From: [Beverly Kluth](#)
To: [CDS User](#); [Jamey Ayling](#)
Cc: [Jeff Kluth](#)
Subject: Fowler Creek Guest Ranch (CU 23-00003).
Date: Monday, October 2, 2023 1:21:34 PM

Exhibit 1 - Fowler Creek Narrative

EXHIBIT 16 - SITE PLAN - FOWLER CREEK GUEST RANCH

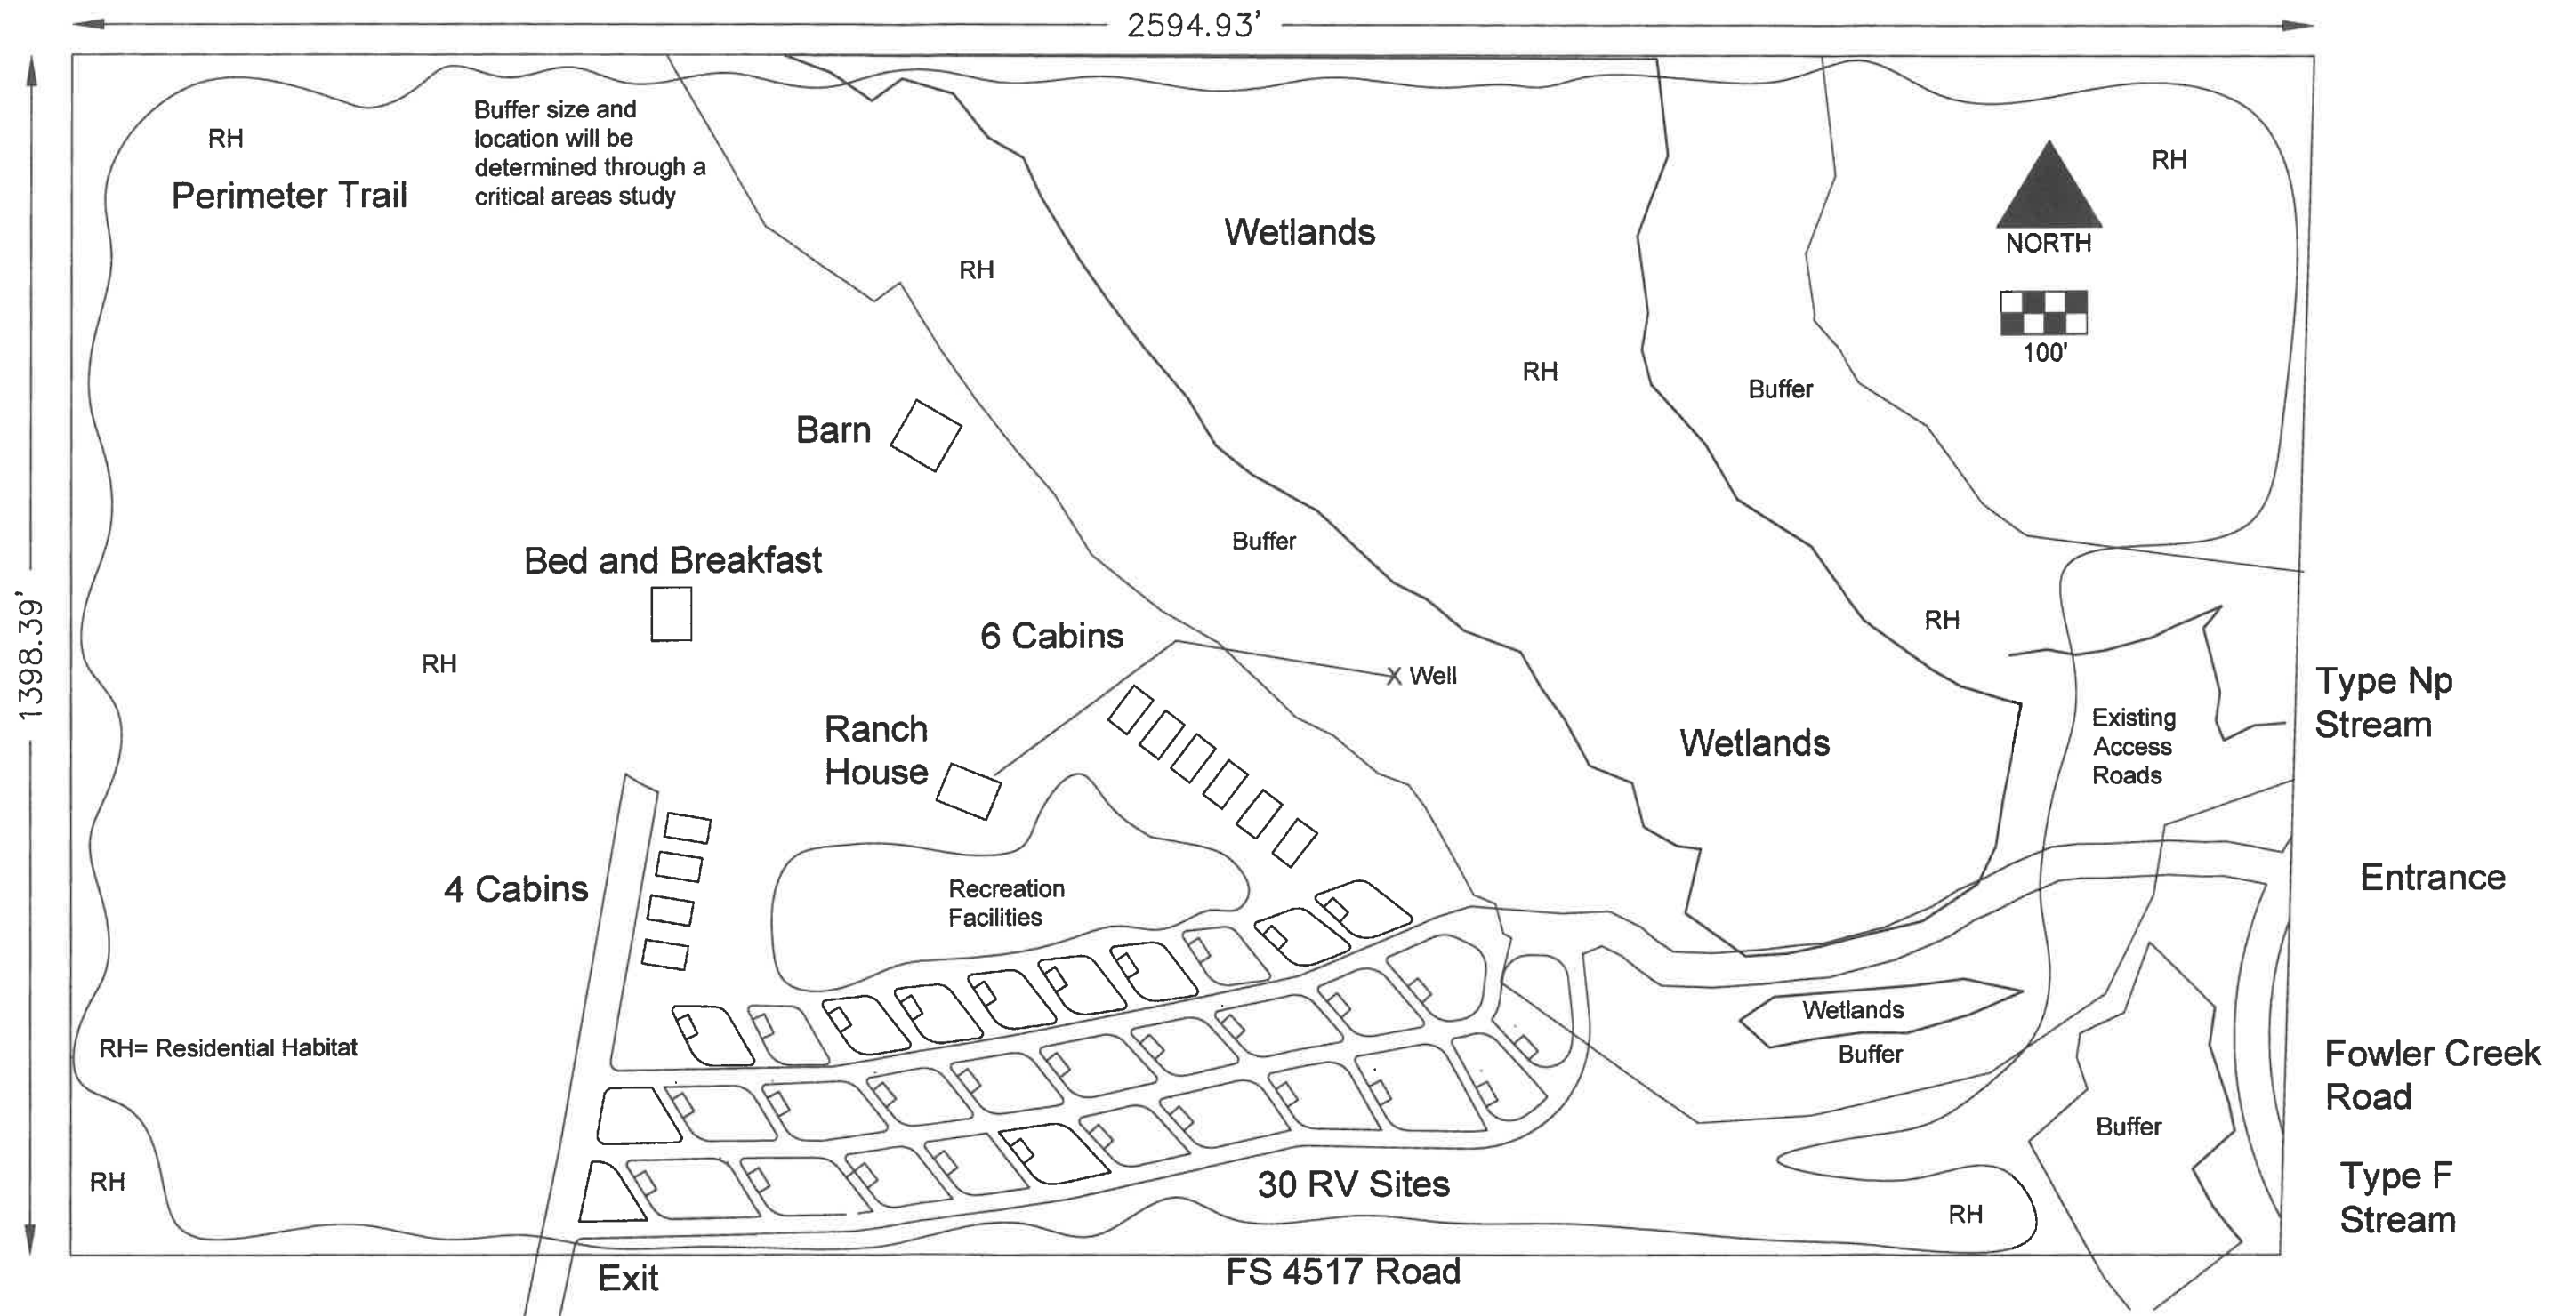
This exhibit is missing much information. It doesn't even list how many of these RHs there will be, it's necessary to review Exhibit 16, Site Plan where I count 8 of them, one is smack dab in the middle of what is designated as Wetlands on the map. Will water or toilet facilities be available for these and if so where? How are the sewage concerns addressed in an ecologically safe manner since these habitats will be situated closer to wild life areas and wetlands? Will there be lights at each habitat? Will they be heated and if so, how? Will these be open year round? Was vehicle traffic by these tourists staying in these habitants added to the numbers in Exhibit 12? This is so very unclear and unacceptable. I'd really like to know what the Department of Fish and Wildlife and the Department of Ecology would have to say about this exhibit, are they aware of this plan?

This exhibit doesn't provide enough detail about the entrances/exits to this resort. In the document titled 'SURROUNDING PROPERTY REVIEW there is reference to an east entrance, west entrance, and a north activities location. There is no indication on the site plan for an east entrance, west entrance or a north activities notation. It's not clear where entrances and exits will exist.
